Sherpa Ref: 20307-LET-001 REV0.DOCX

9 January 2009

**RE: Warwick Farm Printing Project, Application Number 08\_0088**

Further to your request for information in Attachment A of your letter Ref S07/01943, I give the following responses.

PLAN OF
INK STORAGE TANKS

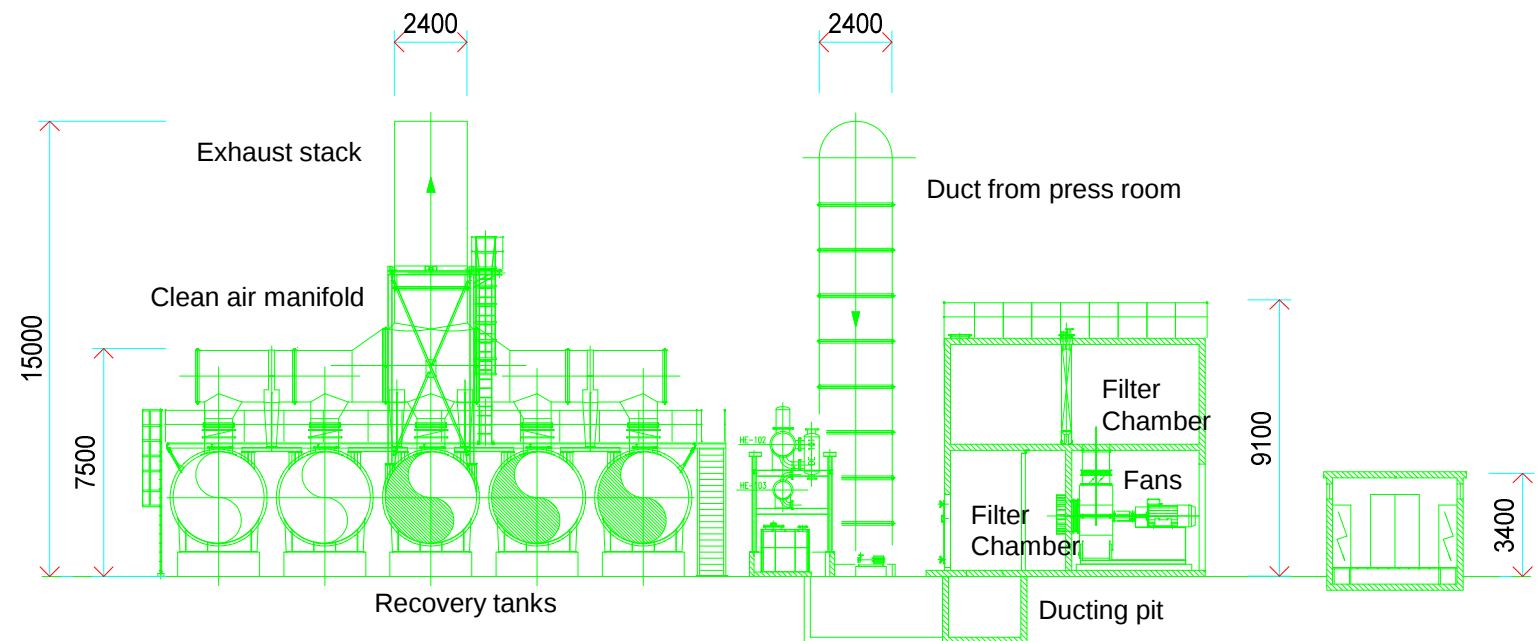
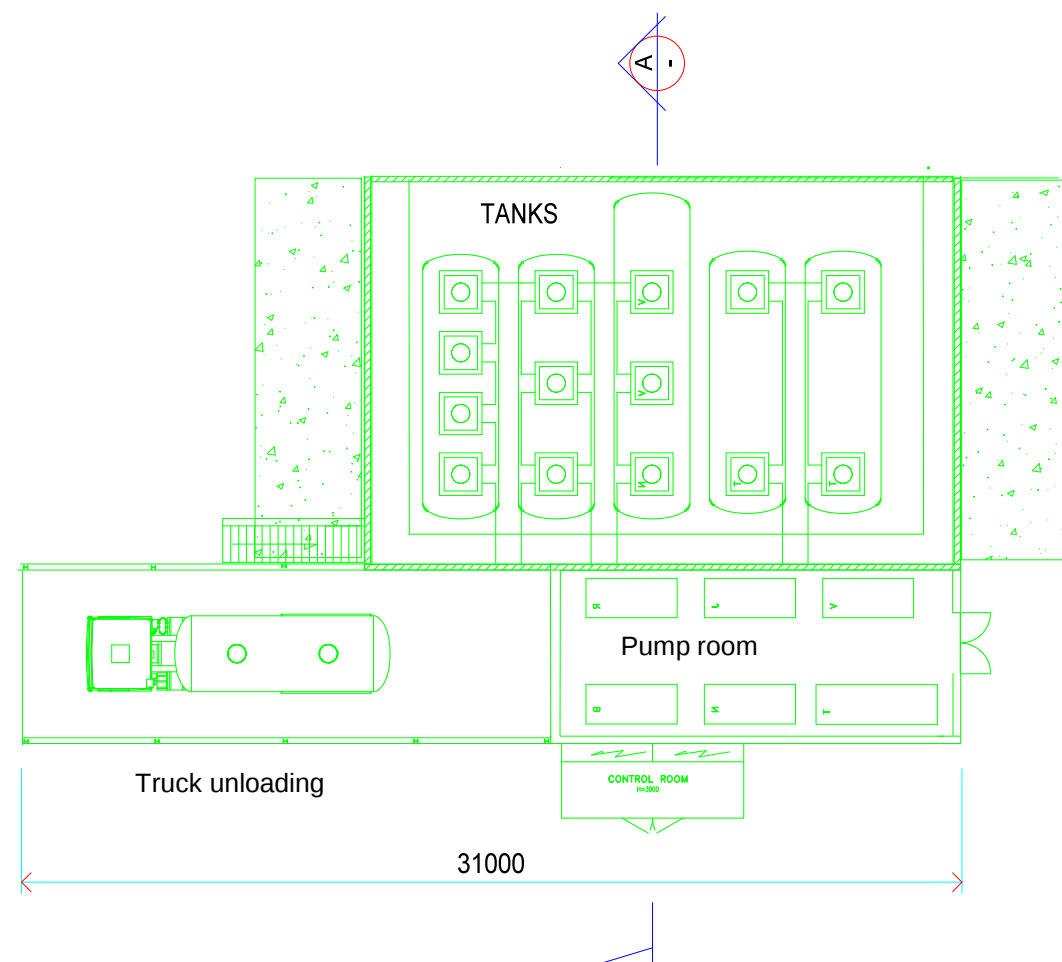
*Item 1 – In case of a fire involving inks, the fire fighting water will be contaminated. Brief information on the arrangements for containing contaminated fire fighting water should be provided.*

The Fire Safety Study, following the requirements of HIPAP 2 (DoP, 1993), and undertaken prior to construction, would normally be used to describe the arrangements for contaminated firewater containment. The design of any firewater retention system required would follow the requirements of 'Best Practice Guidelines for Contaminated Water Retention and Treatment Systems', (McCracken, 1994).

Based on preliminary design information, the following details can be given which will be expanded upon in the Fire Safety Study to include design details for firewater containment:

- bunding for the toluene storage tanks, will be in accordance with the requirements of AS1940 (ME-017, 2004) including an allowance in the bund capacity for firewater application over 20 minutes.
- The printing machines will be fitted with a sophisticated fire detection and extinguishing system using carbon dioxide. This will limit the requirements for water to be used in this area.
- The paper storage area will incorporate a sprinkler system, but is segregated from plant items containing toluene to mitigate fire escalation and contaminated firewater generation.
